Accessibility Compliance

PROJECT NAME: New Maitland Hospital – State Significant Infrastructure Stage 2 Access Report

DATE: 26 March 2019

## 4.0i rehabilitation courtyard - detail plan

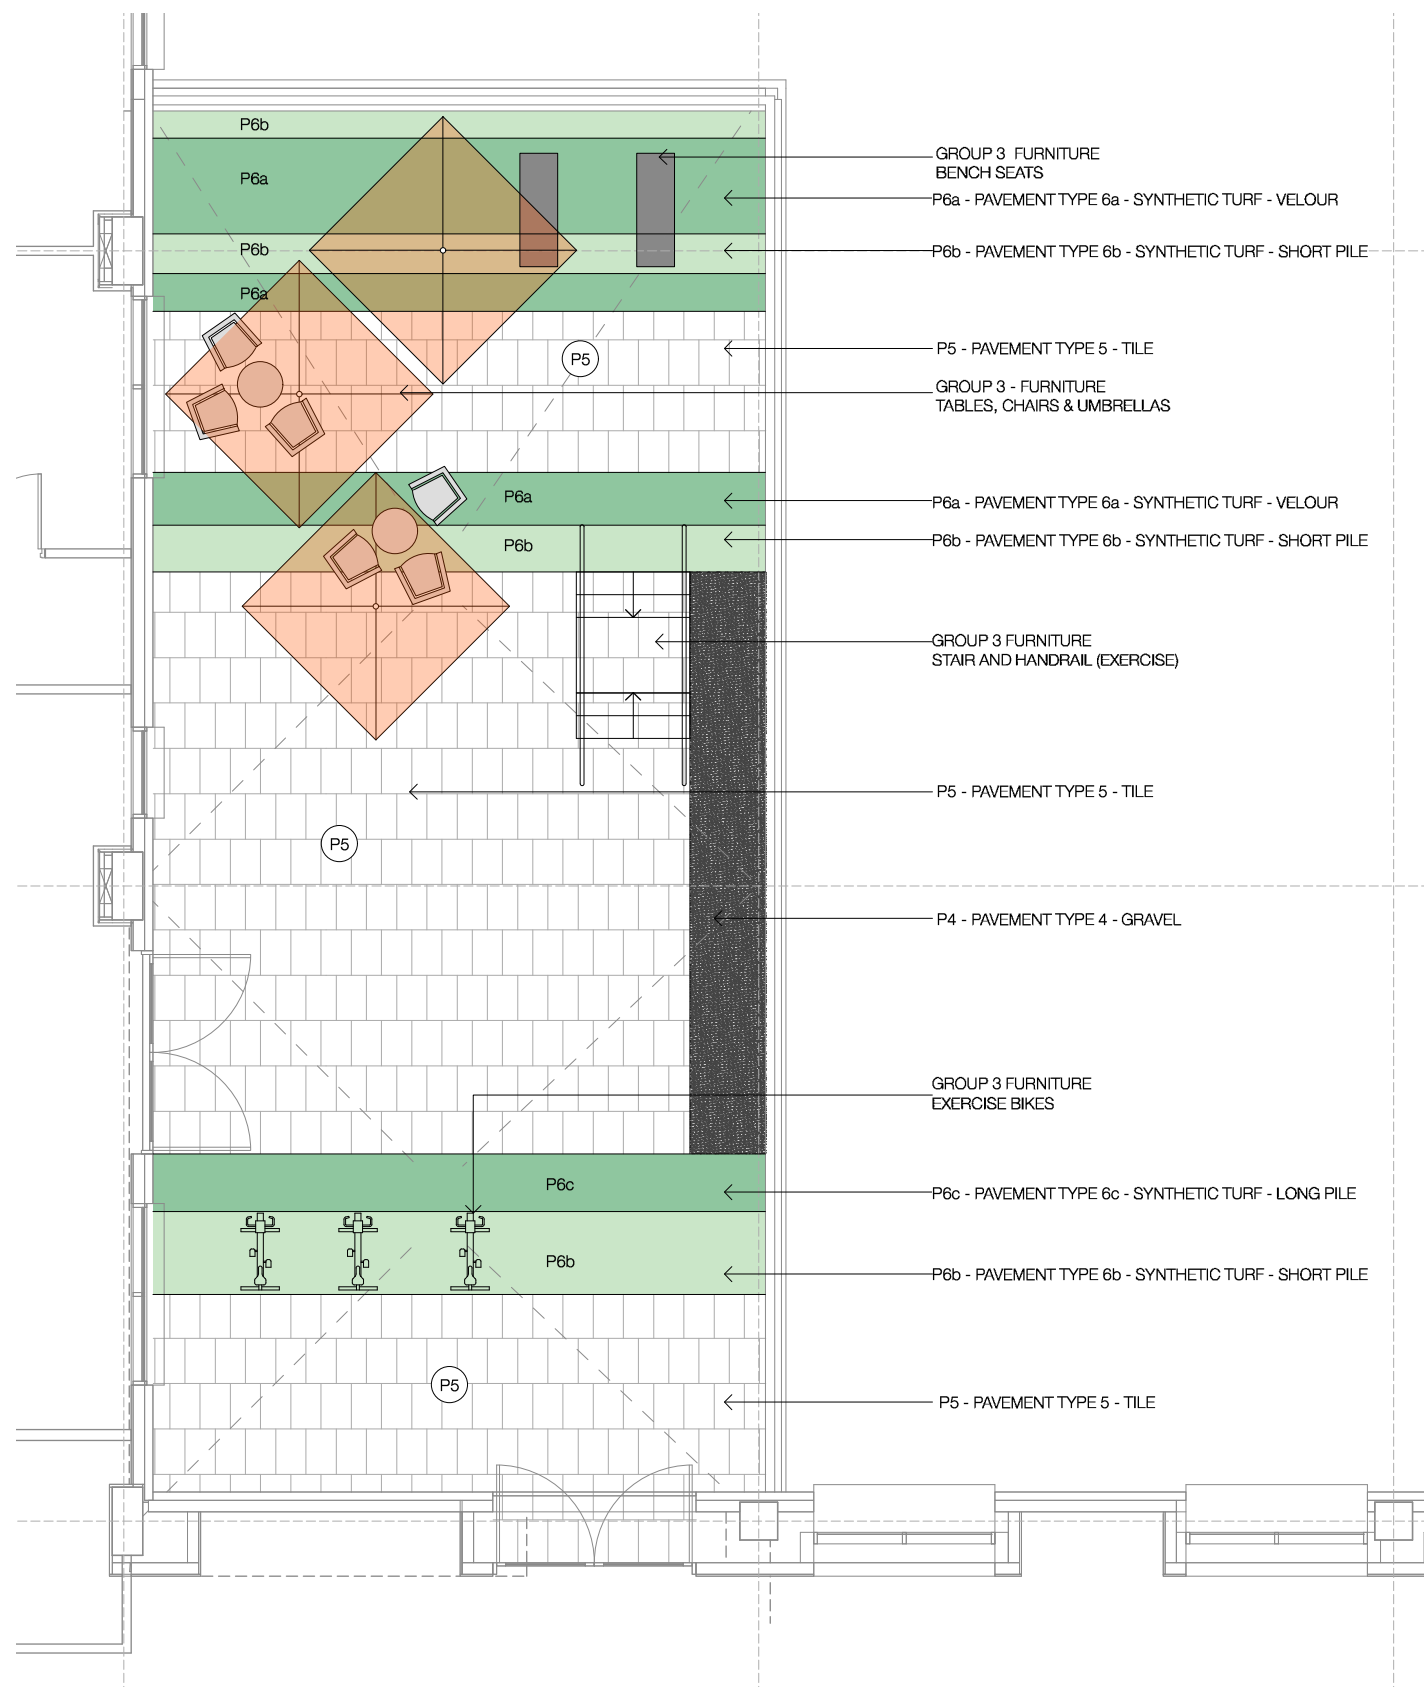
Landscape areas: Landscaping areas designed for the common use of all occupants (whether public, staff, visitors, patients etc.) eg. main entry garden, rehabilitation and other building courtyards etc. are required to be accessible, compliant with AS1428.1. Therefore, a level, continuous and clear accessway will be required to and within these areas, compliant with AS1428.1.

During design development stage, all accessways will be developed and documented to confirm required access features for people with disability including: continuous accessible paths of travel with suitable gradients and lengths between landings, suitable cross-fall and level transitions between internal and external areas, slip resistant traversable surfaces, and circulation areas in compliance with AS1428.1 to satisfy BCA/DDA Access code Part D3.

## 8.0 appendix a - stage 2 state significant infrastructure application - landsape plans

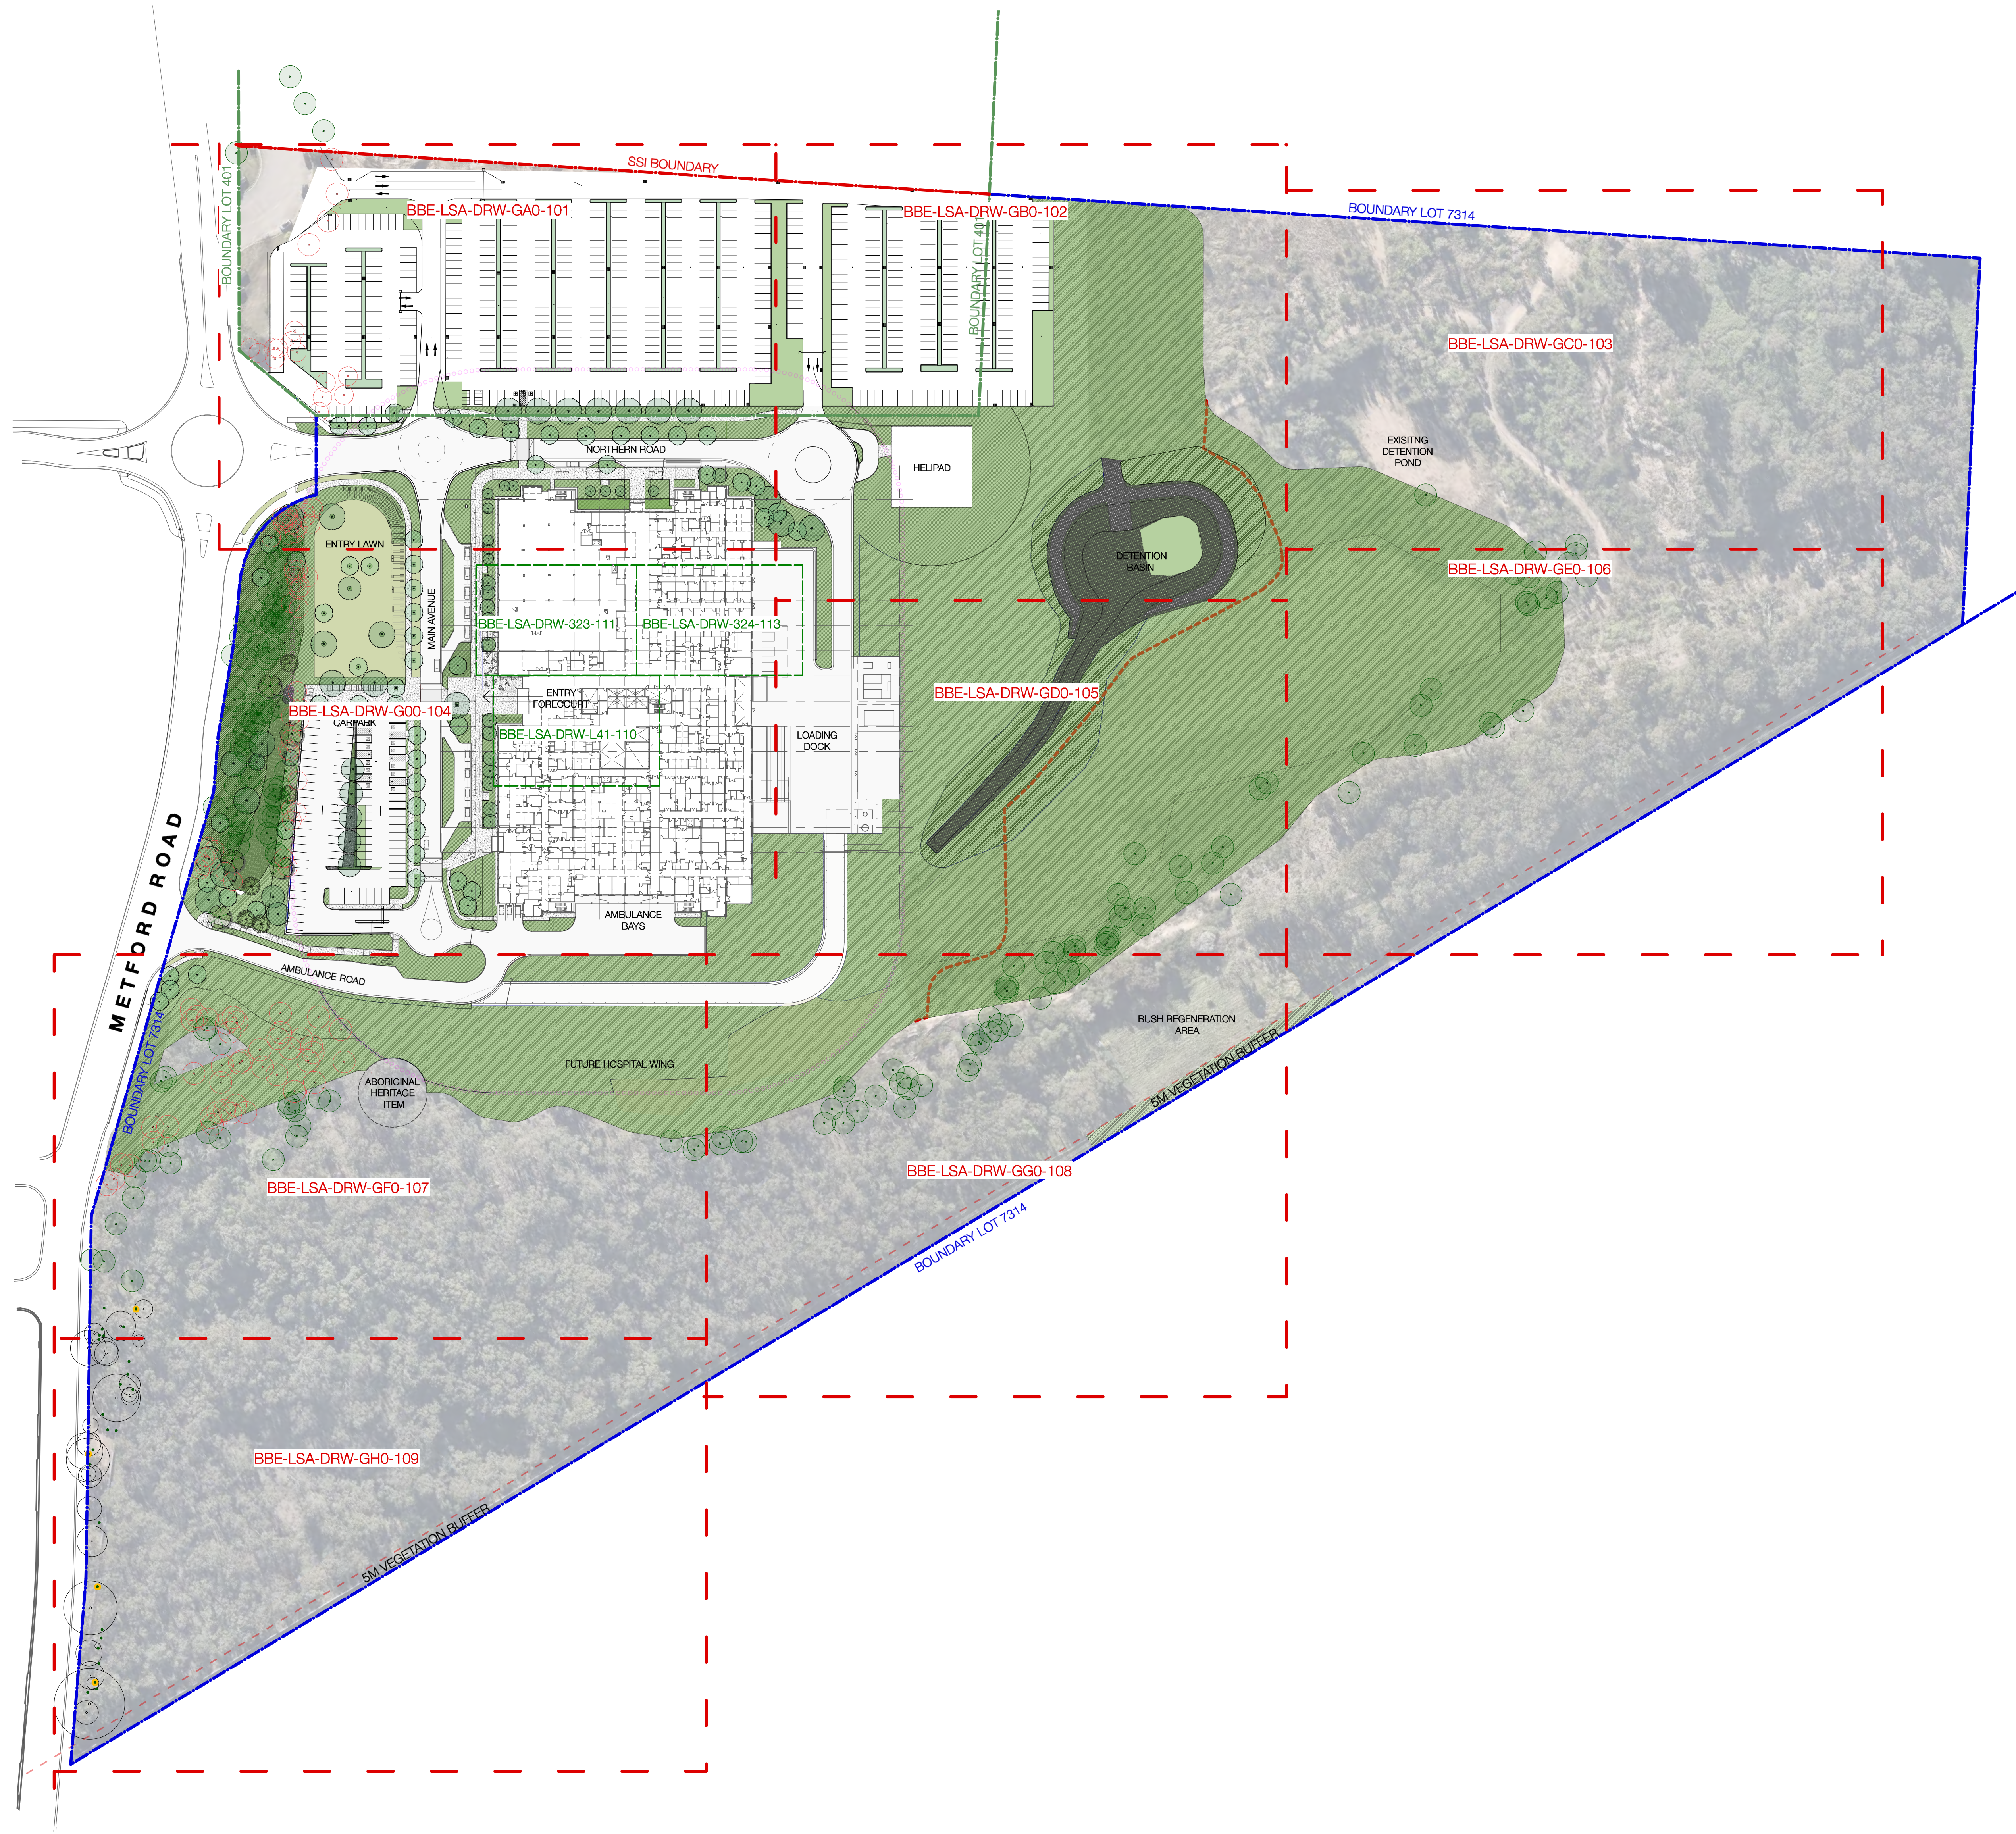
- Southern ramp access must comply with AS1428.1 and not exceed a vertical rise of 3.6M to be accessible and not cause undue fatigue for people with disability. Due to extensive length, at least 1800mm min. clear width (between handrails) is required for wheelchair passing bays. Including hardstand level landing areas (with seating) is recommended adjacent ramp at top and base areas to provide rest areas (DDA/Advisory);

- On-going design of public bus-stop and taxi-stand at north and north-east of building needs to be developed in accordance with Disability Standards Accessible Public Transport (DSAPT), AS1428.2 and AS1428.4.1, with kerb -ramp connections to roadway. Note: generally, a 150mm kerb-height is required for deployment of ramps from accessible buses.

- Internal roadway drop-off areas indicated have same grade/flush transitions to pedestrian accessways that will assist people with limited mobility but may cause issues for people with vision impairment if not suitably delineated. While not directly adjacent to building entrances, that would necessitate use of TGSIs to meet BCA Part D3.8 (e), TGSIs should be installed in addition to bollards as per. AHFG Part C Section 4.6 recommendations and to minimise potential DDA risk (DDA/Advisory).
